# V1 Drainage Report - Final.pdf Markup Summary

Powers & Grinnell

APPENDIX F
Drainage Maps

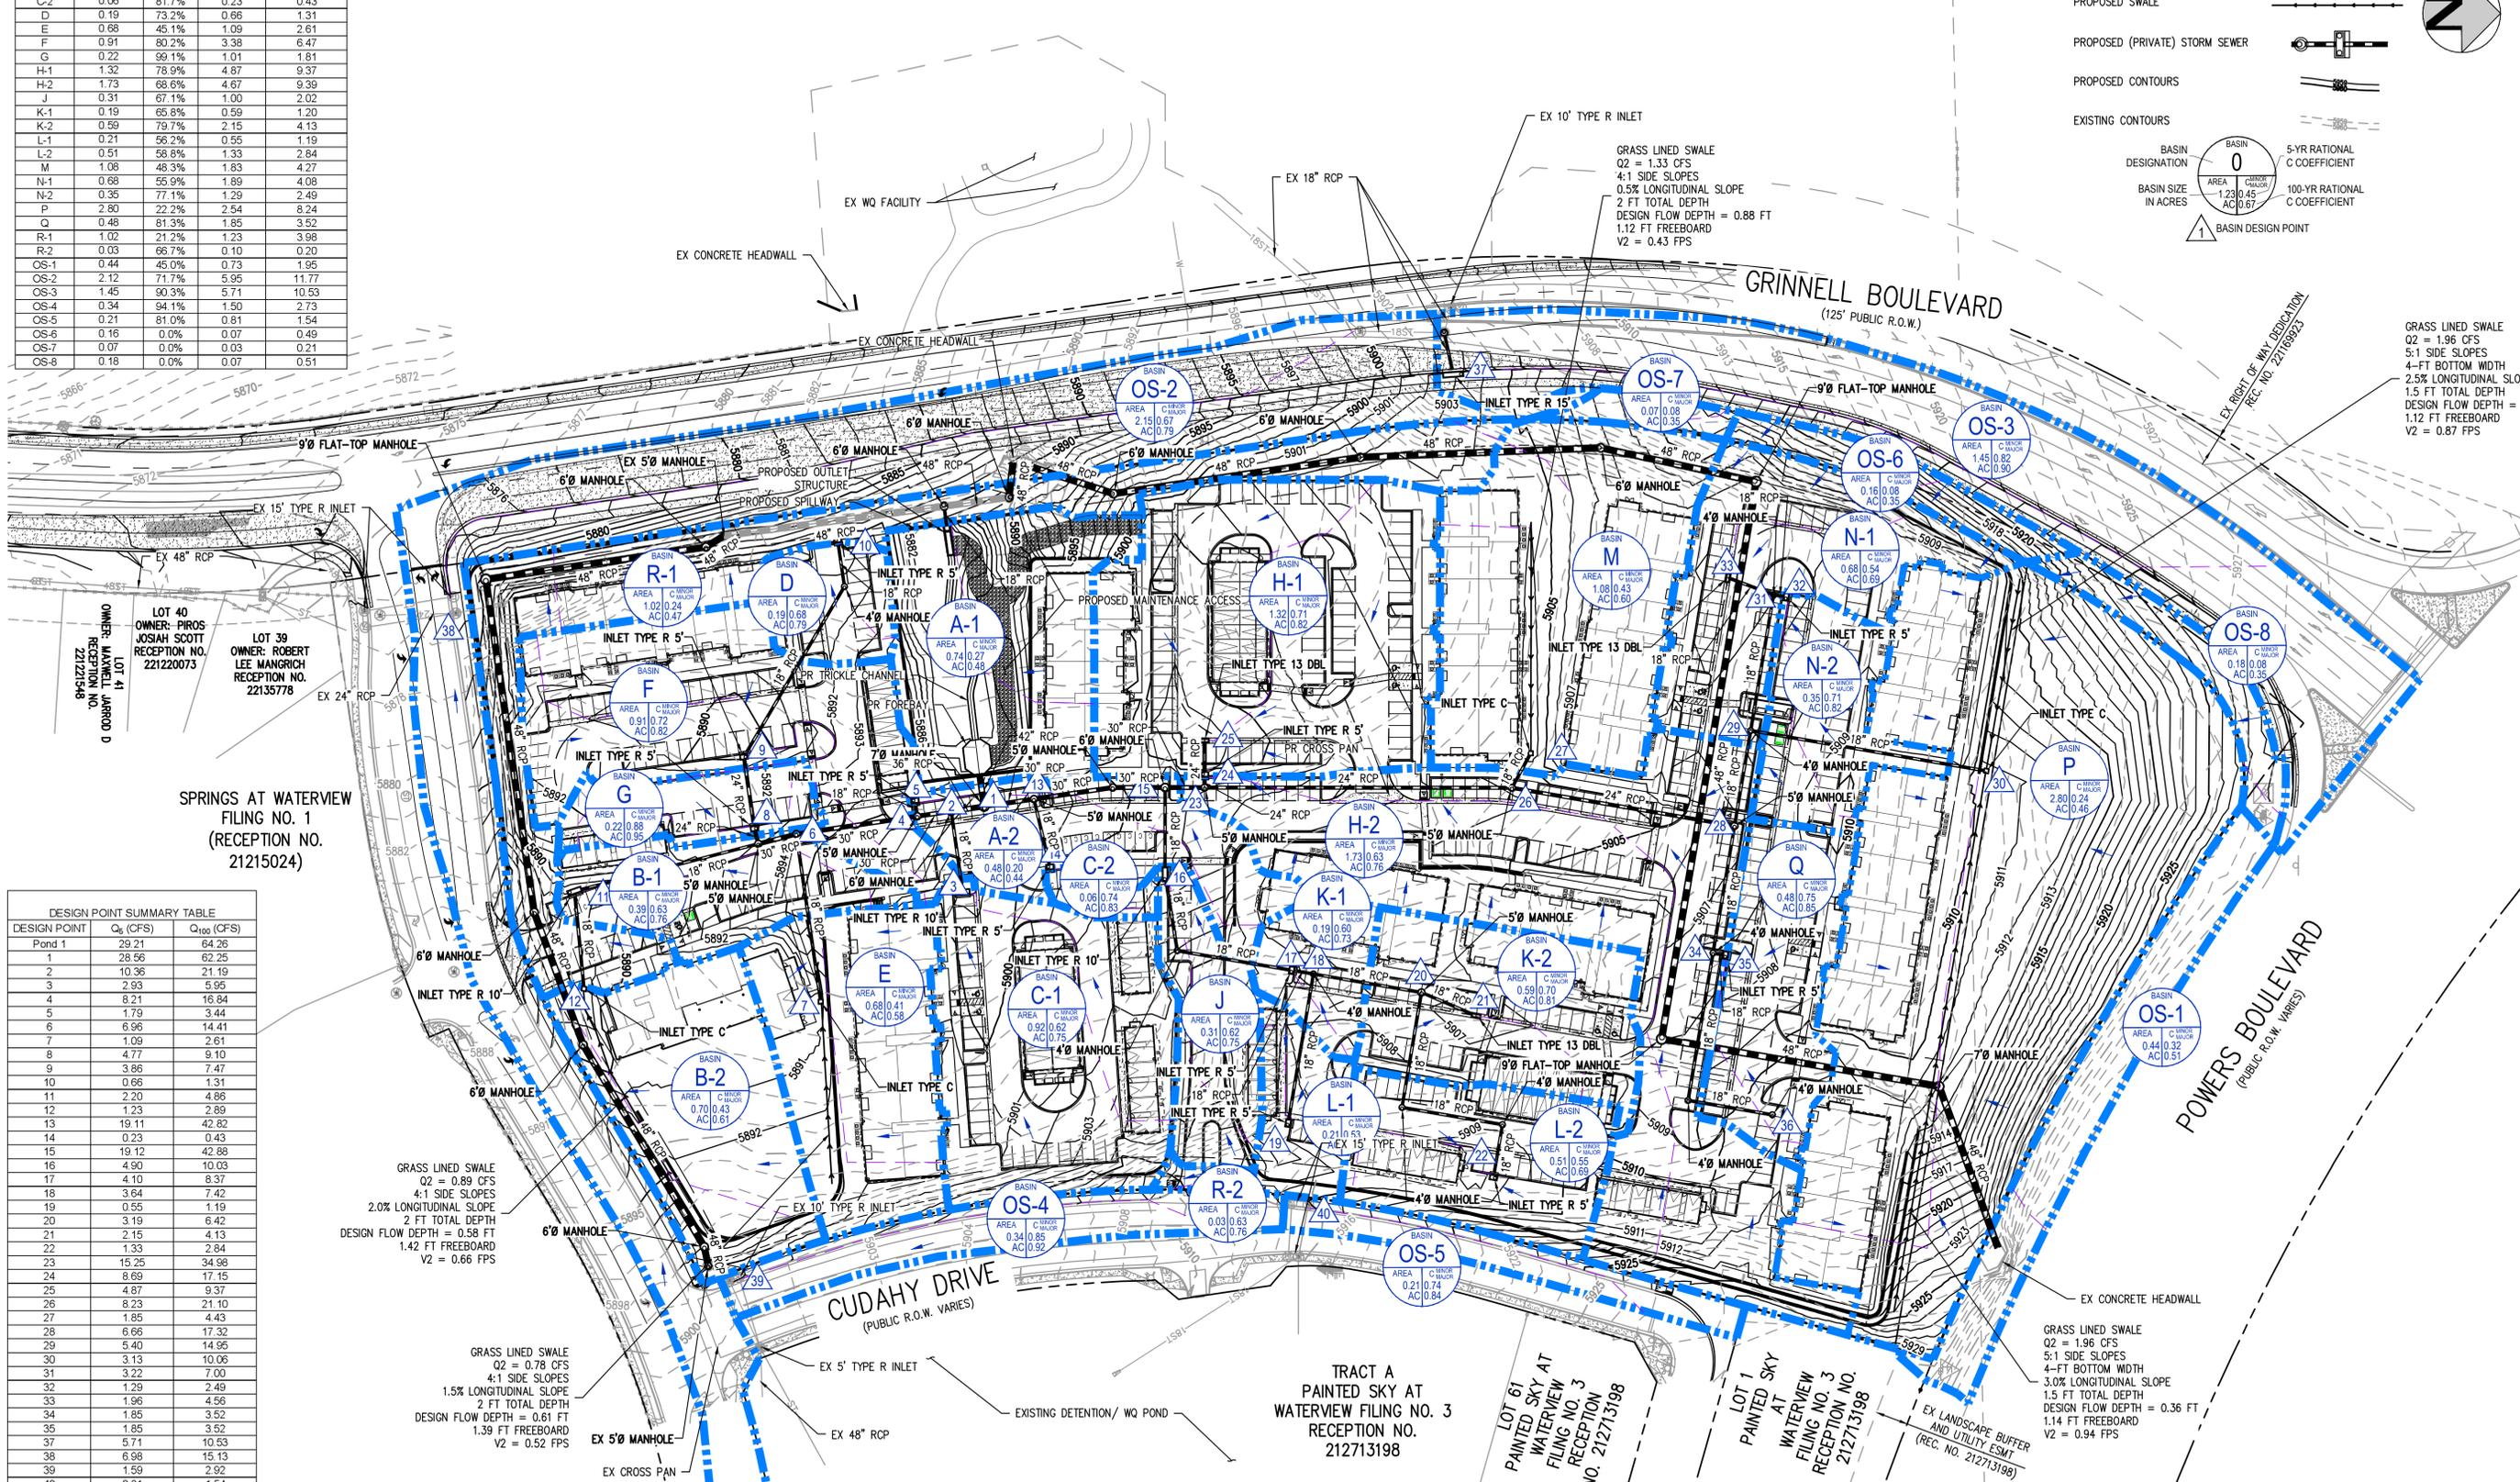
Sub-basin is missing label. Please revise and account for in report.

Show and label 8'x6' culvert

Label box shapes

Label culverts

Show existing riprap inside of the channel.

Flows from basin R-1 need to drain towards the water quality detention pond.

Extend analysis to include the improvements south of Goldfield Road.

Add a design point at the ultimate outfall. Flows at this location must be equal to or less than the "Existing Drainage Plan" Design Point 1.

Appears to be a rundown/chase. Please label

What are these? Please label

Include basin that was shown on existing drainage map for this half of street

Basin P should be broken up into 2 basins so east and west swales can be designed accordingly (Different flows, slopes, lengths, etc)

Label gutter/cross pans. Provide design calculations for pan widths
